From: Amanda Scholes on behalf of Planning.Responses
Sent: 02 July 2020 07:18
To: Planning Scanning
Subject: FW: BN/18/20/PL, Former Brook Nursery PLAN 031142
Attachments: RE: BN/18/20/PL, Former Brooks Nursery, Eastergate note to Arun 200625

From: Maria Tomalova [<mailto:Maria.Tomalova@arun.gov.uk>]
Sent: 29 June 2020 16:42
To: Edevane, Joff [REDACTED]
Subject: BN/18/20/PL, Former Brook Nursery

With regard to our recent phone conversation I would like to ask you for further information since the above application has been deferred at committee for more information:
Why/if pipe could not connect to main sewer in Barnham Road.

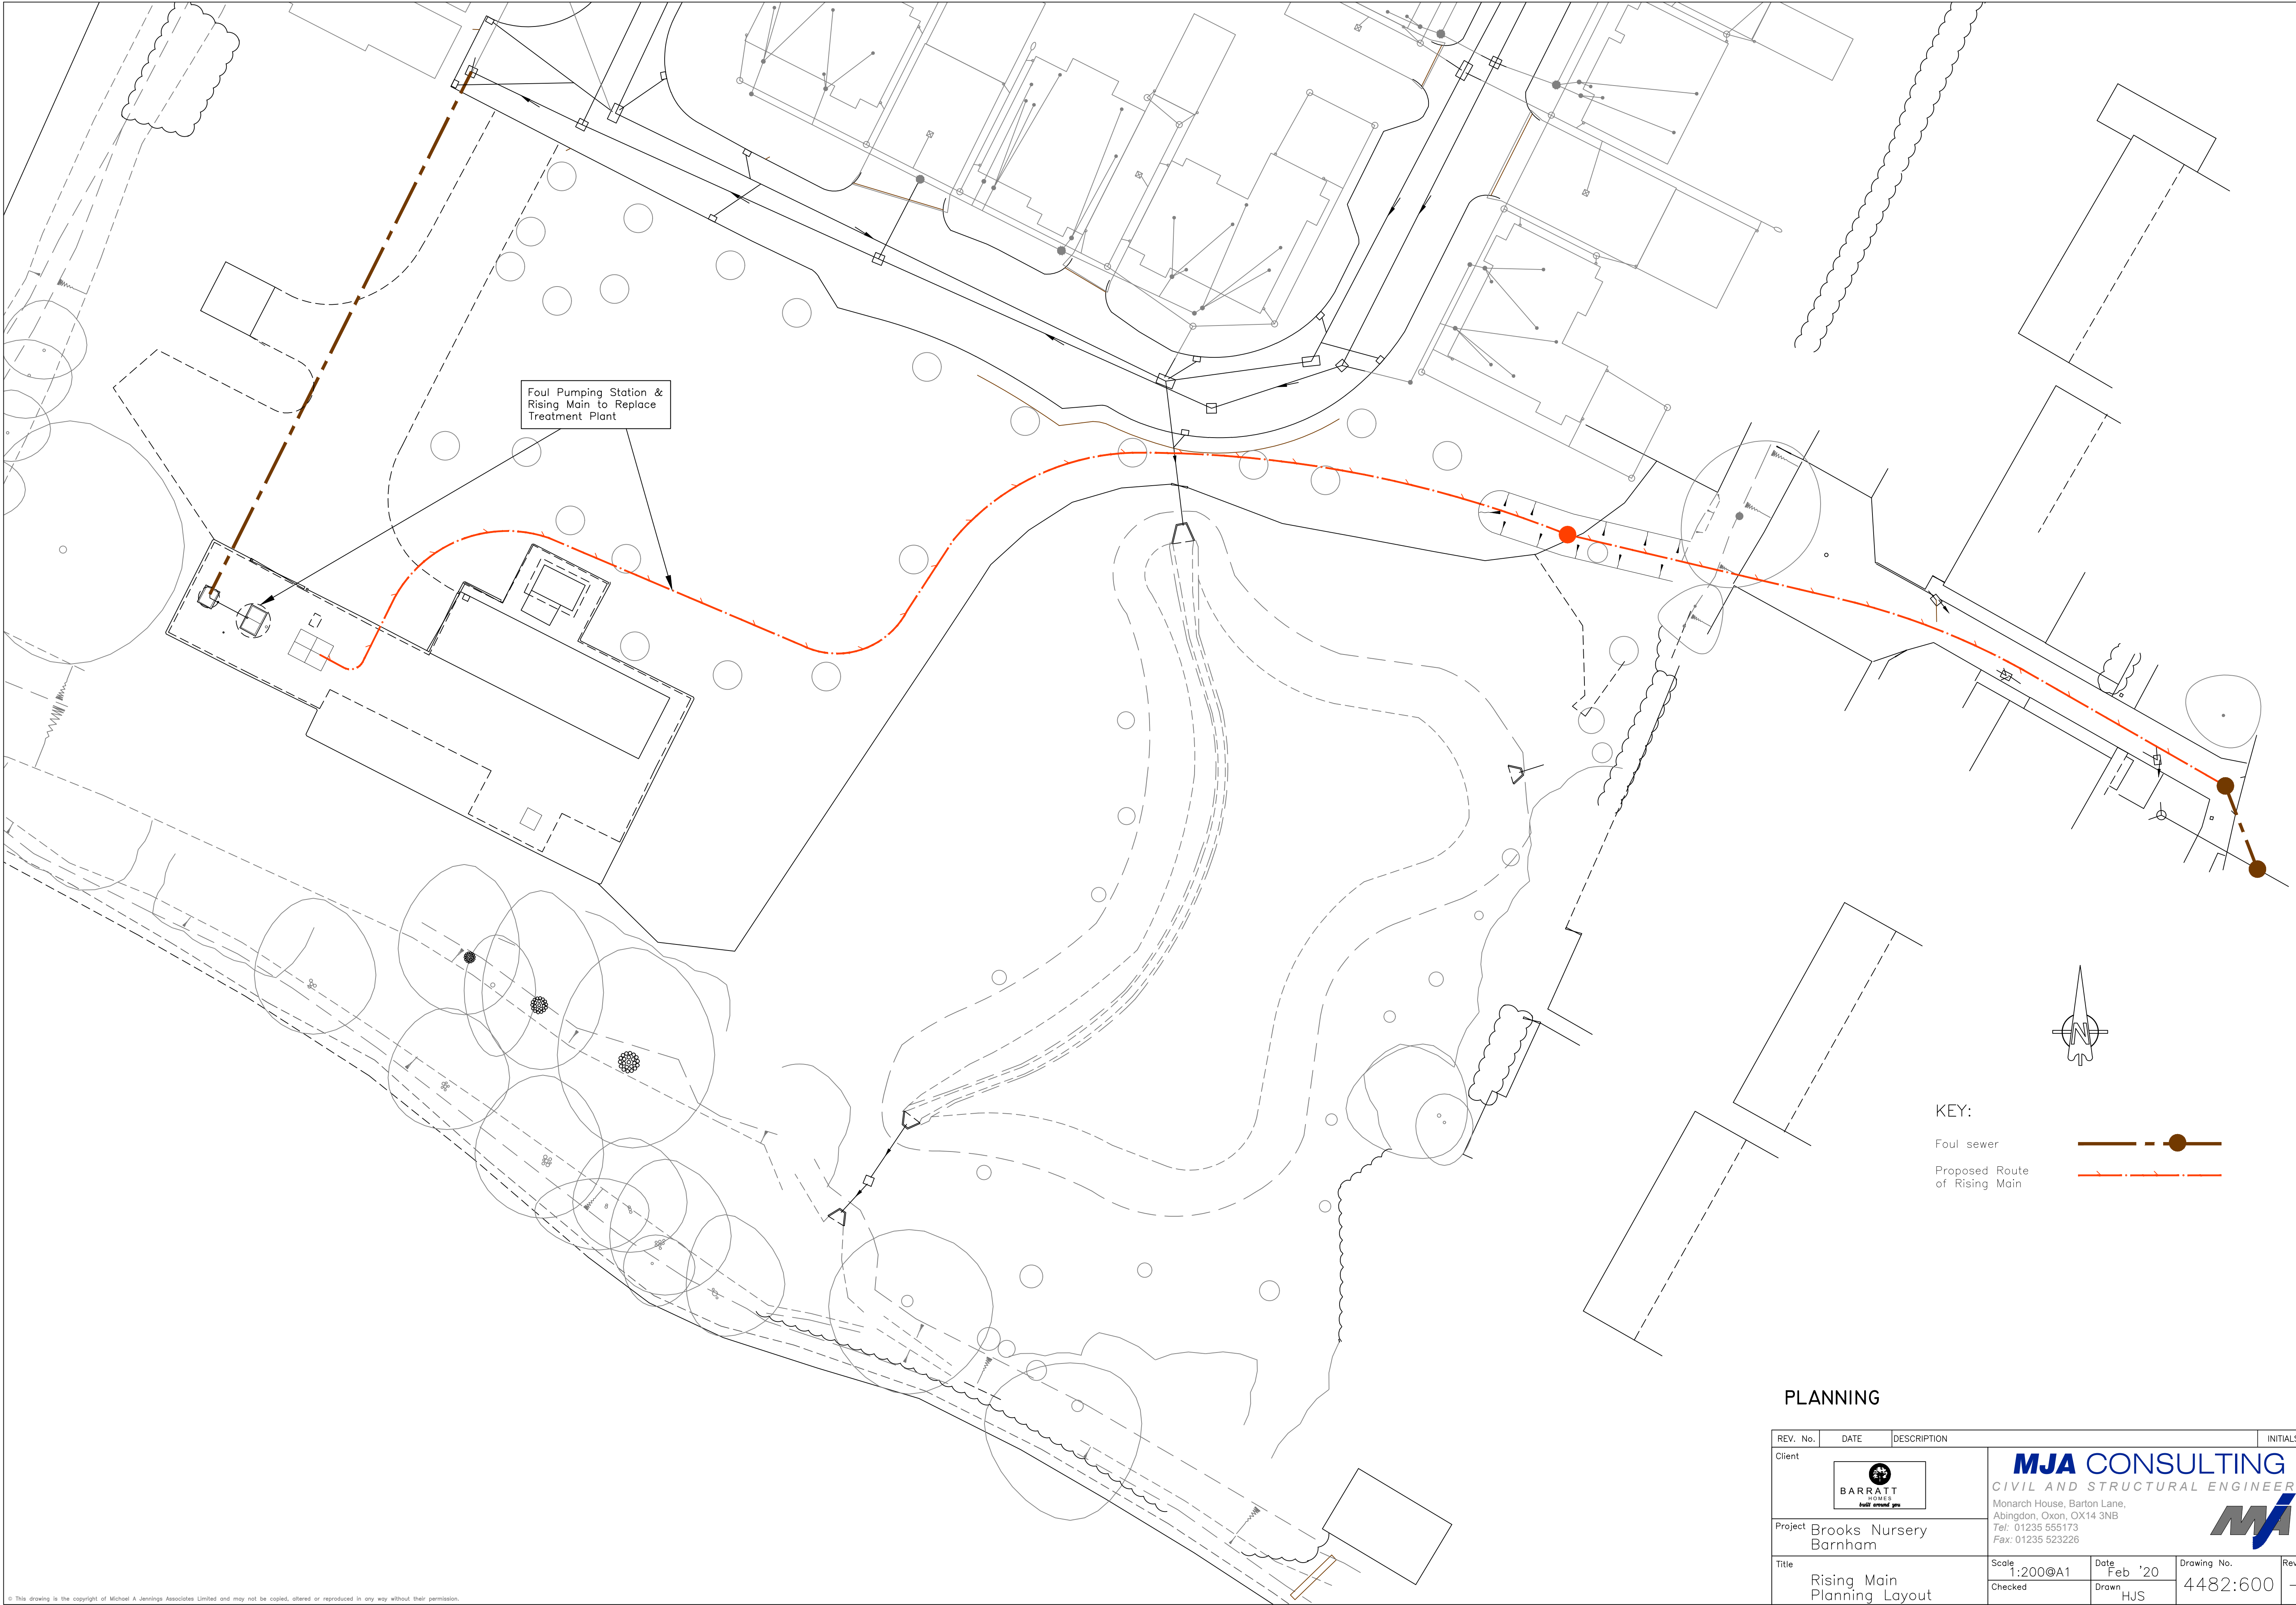
'The developer has proposed a connection to manhole SU95043802 on Elm Grove South to the east of the site but other locations are being considered.'

The question is if it can go to Barnham Road directly without journey through Elm Grove South.
This is a request from management not my curiosity.

A scheme to look at providing reinforcement for this development is currently being progressed through our section 98 requisition process and the outline design is with our engineering team.

The applicant has confirmed the design and construction of the pumping station, together with the section of rising main within the site boundary, will be undertaken by the developer. The final circa 45m of rising main and connection to the existing public sewer is to be undertaken by SWS under the S98 mechanism, due to the need to cross third party land. The developer has proposed a connection to manhole SU95043802 on Elm Grove South to the east of the site but other locations are being considered.

The final point of connection will be determined as the design progresses and this will form part of the wider design for the Lidsey Waste Water Treatment Works catchment. The growth design study has commenced but no completion date has been identified at this point in time and at present I do not know when this will be decided.
